**KIRKLEES METROPOLITAN COUNCIL
INVESTMENT & REGENERATION SERVICE**

DELEGATED DECISION TO DETERMINE PLANNING APPLICATIONS

Reference No:	2025/62/92912/W
Site Address:	87A, Kaye Lane, Almondbury, Huddersfield, HD5 8XT
Description:	Erection of a single storey extension and rear roof dormer, hip to gable and associated external alterations.
Recommending Officer:	Laura Yeadon

DECISION - REFUSED

H1245A 100 Rev 0

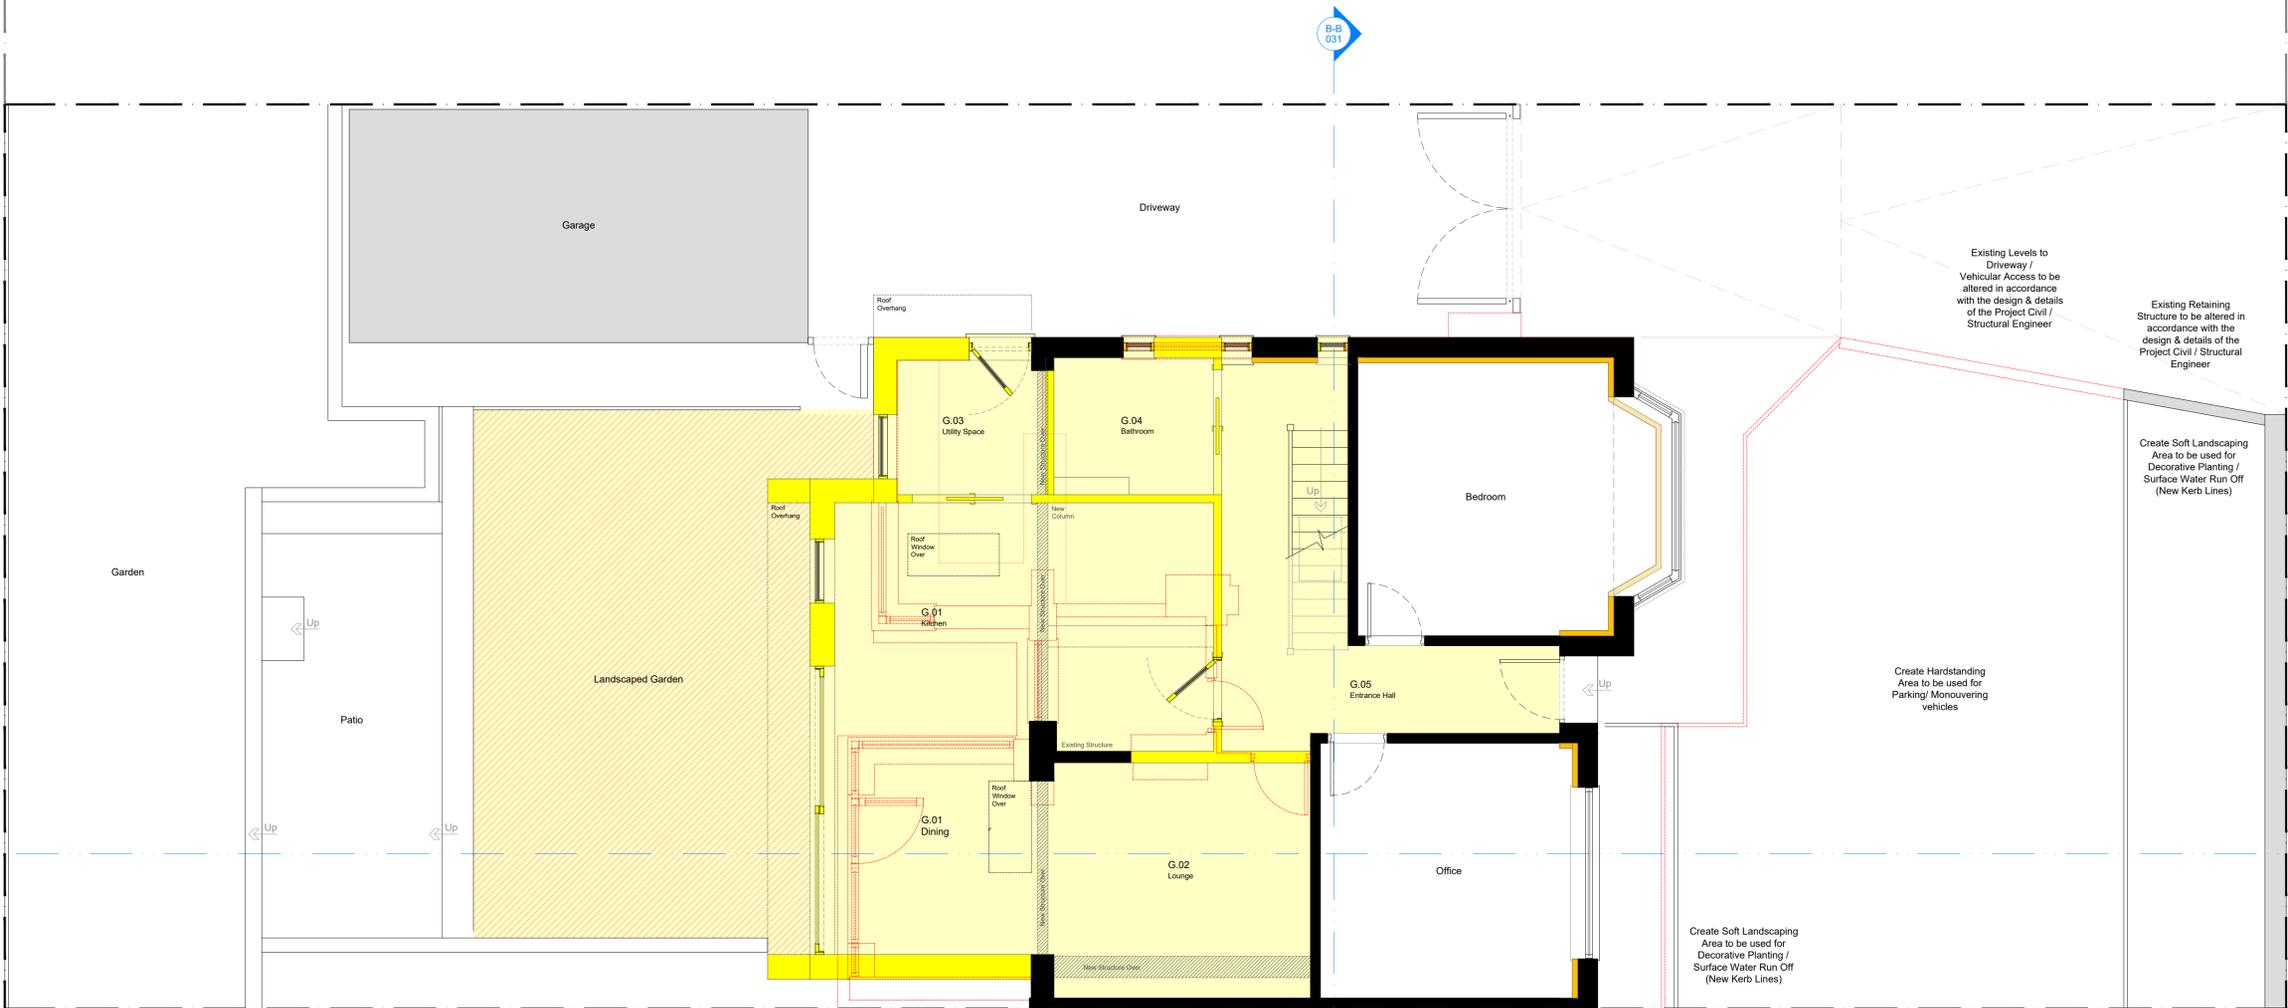
The proposed single storey extension would project 3.7 metres from the rear elevation of the property with a width of 7 metres and flat roof height of 3 metres. The extension would be part rendered and part timber clad.

Attached to the proposed extension is part of an existing rear projection that would be retained with a projection of 2.3 metres with an overall height of 3 metres to attach and be in line with the proposed extension. This would also be part rendered and part timber clad.

H1245A 202 Rev 0

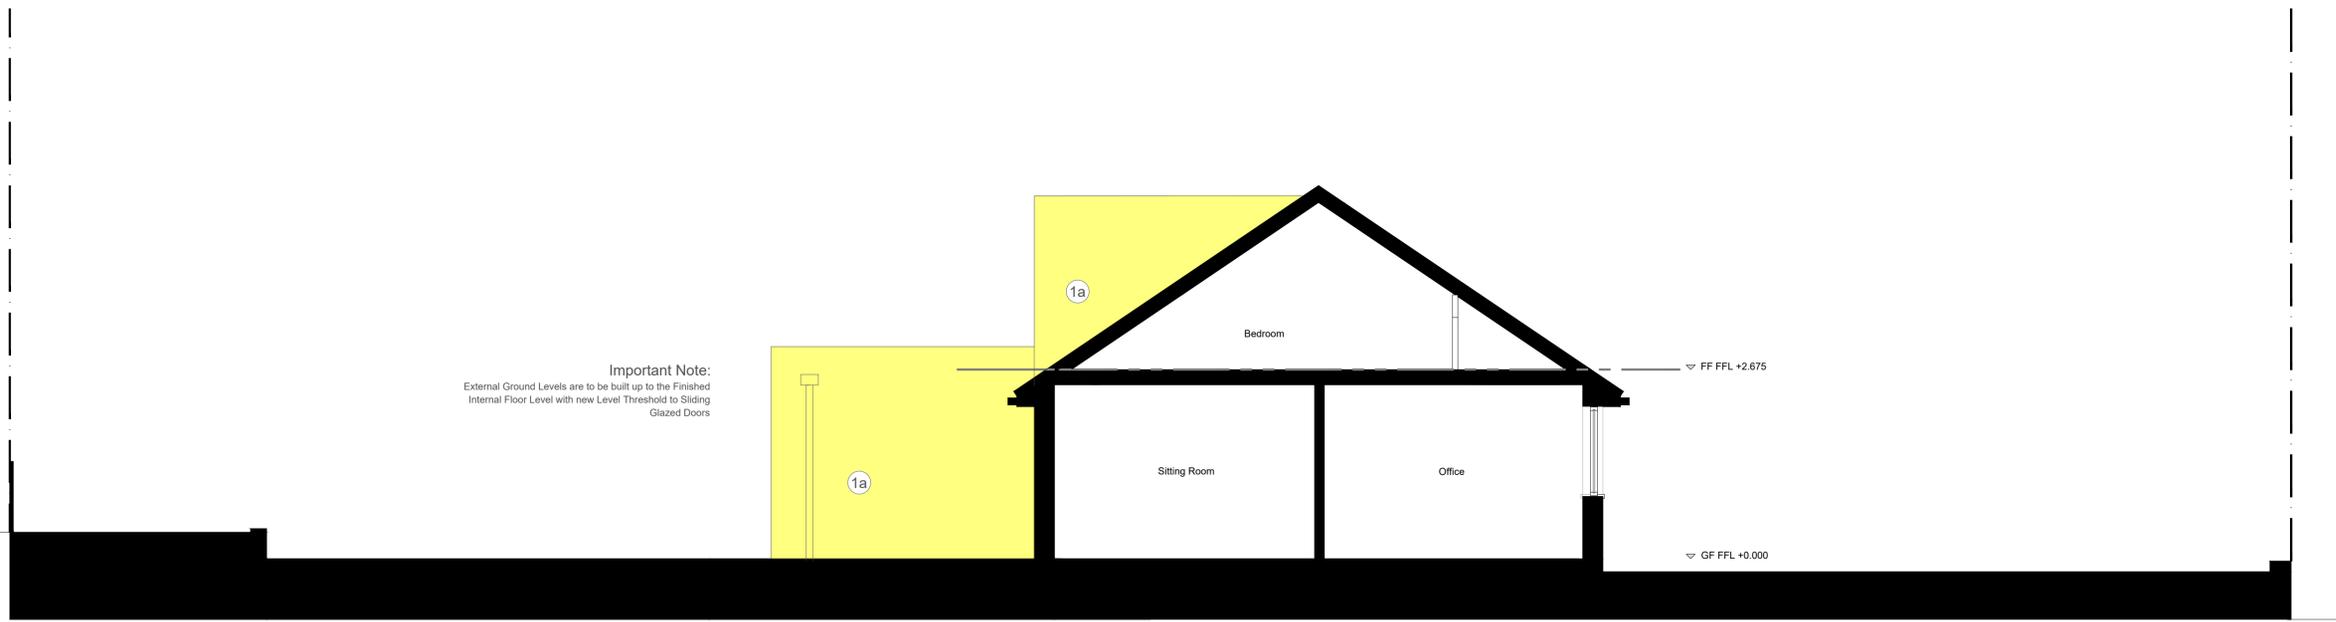
The front elevation of the property would remain mostly unchanged with the exception of the hip-to gable roof form. The first floor side elevation and the side elevation of the extensions would be rendered in white with part cedar cladding. In addition, it is proposed that 2 no. chimney stacks would be removed and also 3 no. floor to ceiling openings within the existing side elevation of the dwelling. It is also proposed that additional hardstanding would be created to the front of the property.

In this case, the proposal would alter the style of the property with a hip to gable roof form which would clearly unbalance the pair of semi-detached properties. However, it is noted that the proposed hip to gable roof form can be achieved by exercising permitted development rights which allows for this form of development, subject to conditions. A Certificate of Lawfulness has been granted for the property in order to establish a lawful 'fall back' position in terms of this alteration however the conditions of the Part B of the GPDO is that the materials of construction materials must match the materials used on the existing property. The use of the render to the side elevation in such a stark colour (white) would further emphasise the alteration.

H1245A 201 Rev 0

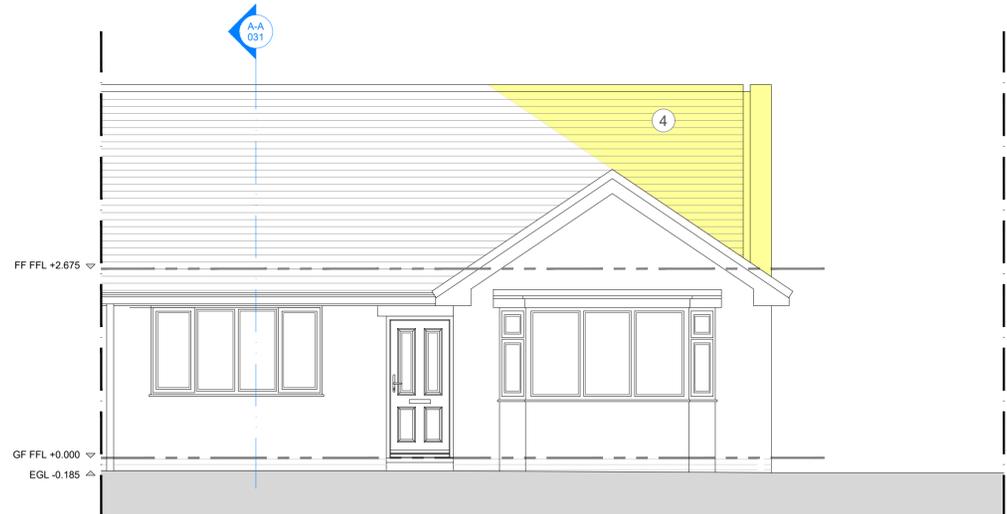
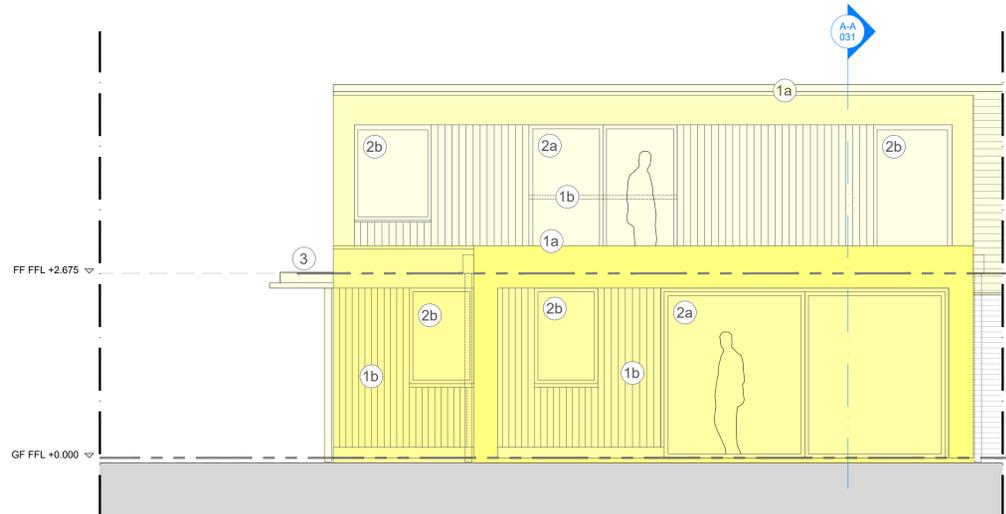
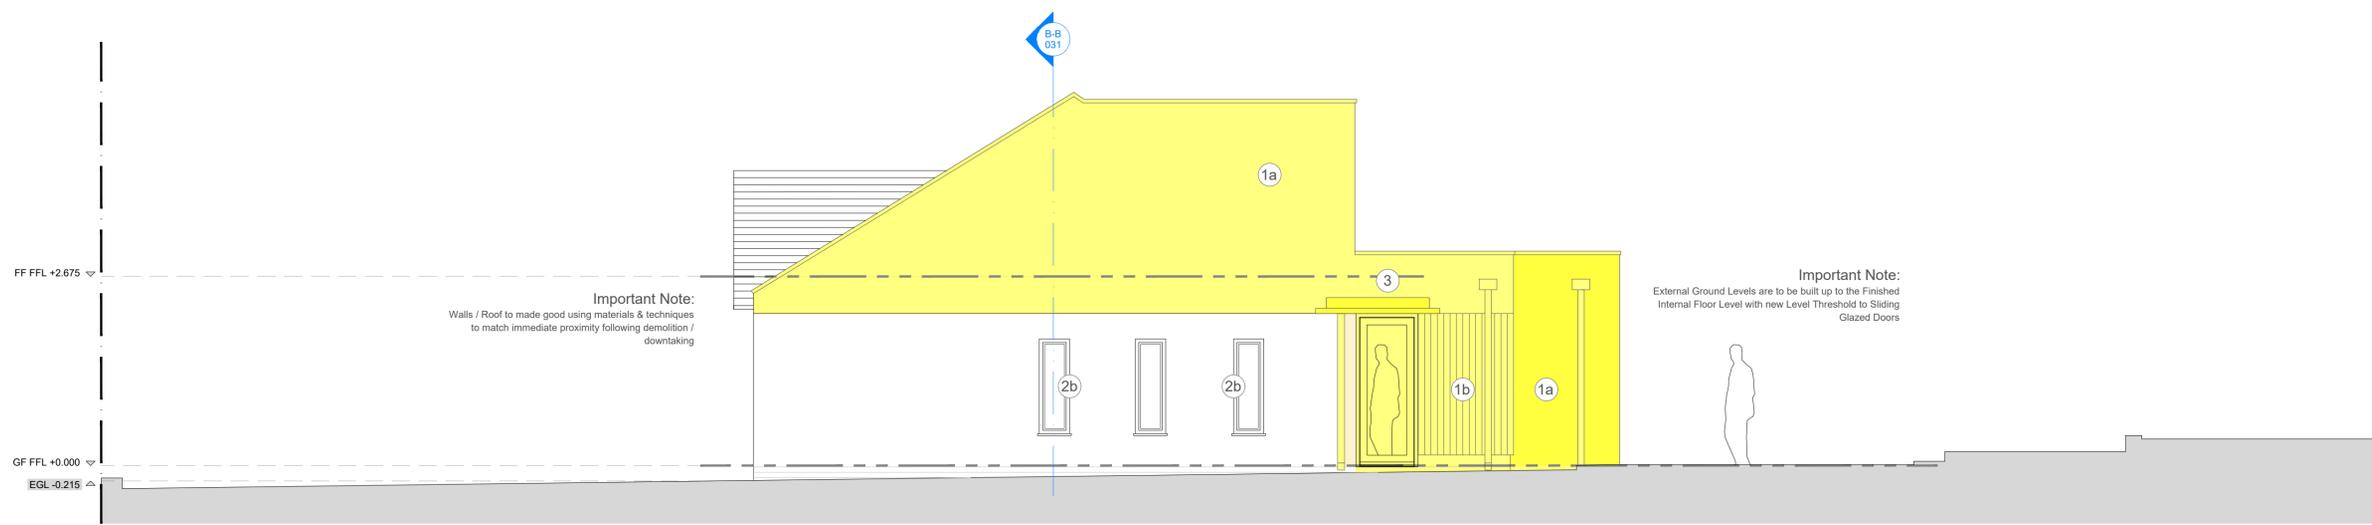
The current proposal seeks to change the visual appearance from the previous application by altering the roof form to a hip to gable and extending the dormer extension both in width and depth with the visual appearance of 'box shaped' structure sitting above the single storey flat roofed extension.

The dormer extension would span the full width of the existing and extended roof with a larger projection than the previous dormer which would be set down marginally from the roof ridge. However the proposed roof form would dominate the rear of the property which would be visible from public vantage points along the Public Right of Way within the field to the rear of the property with the design resulting in a modern design which would not be in keeping with the design of the semi-detached dwellings with a design and material palette that would not harmonise with the host building.

H1245A 301 Rev 0

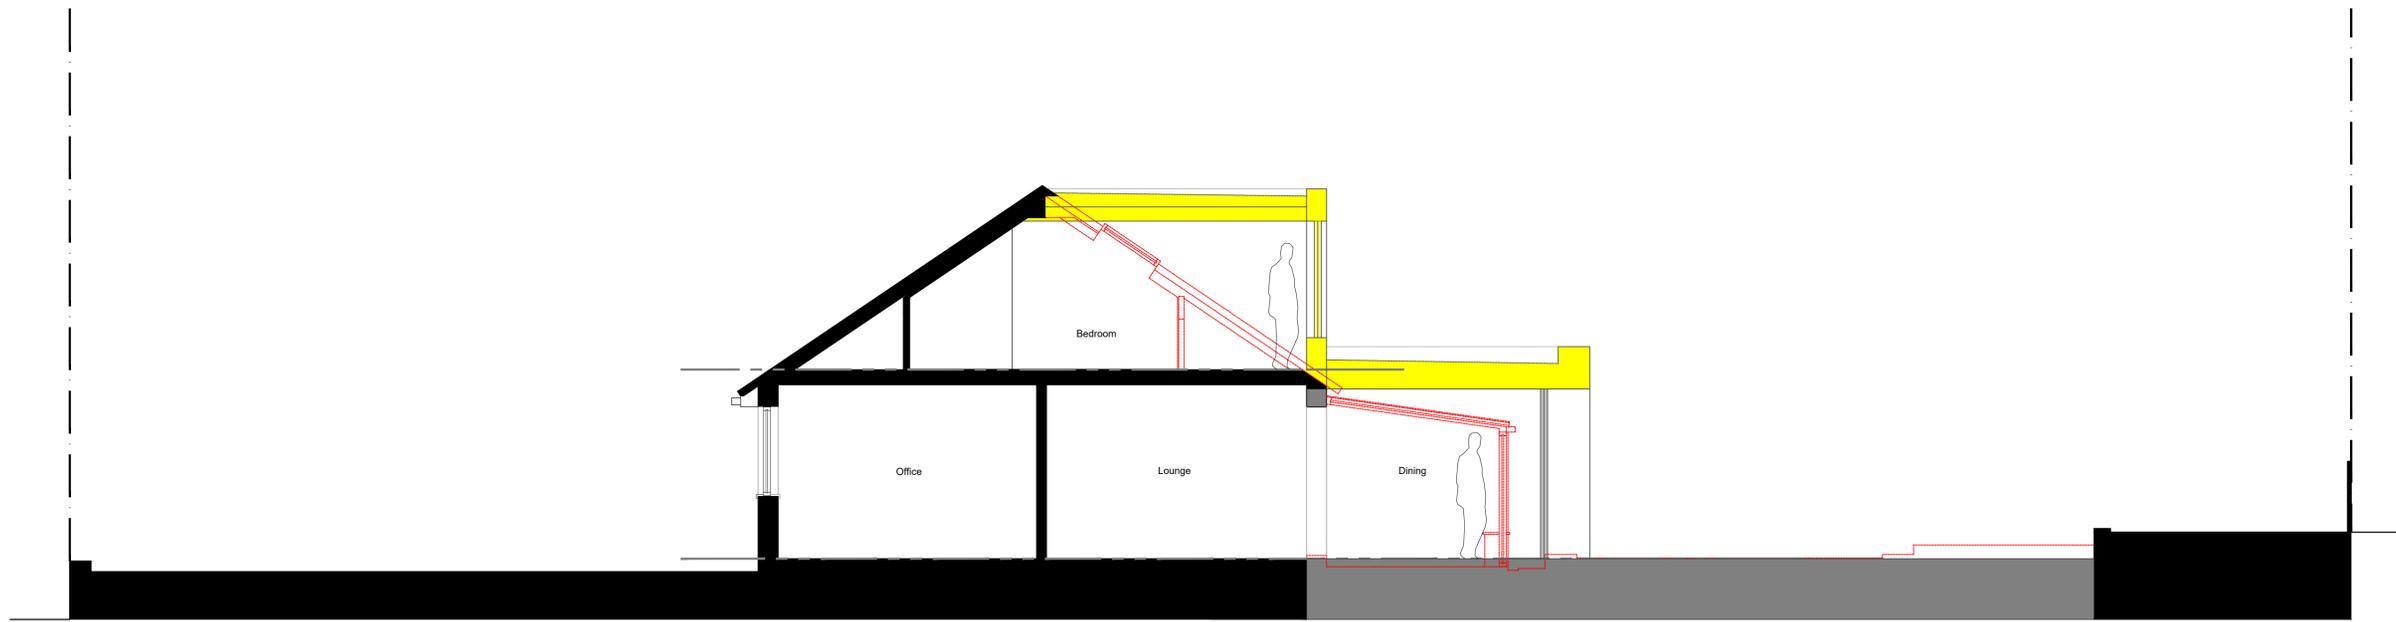
The proposed dormer would be located on the rear elevation of the property tying into the ground floor extension. The dormer would lie flush with the side elevation of the property and would span the full width of the roof form being set in from the shared boundary with the attached property by 0.4 metres. The dormer would be set down from the roof ridge by 0.1 metres. The finishing materials would be part render and part timber clad.
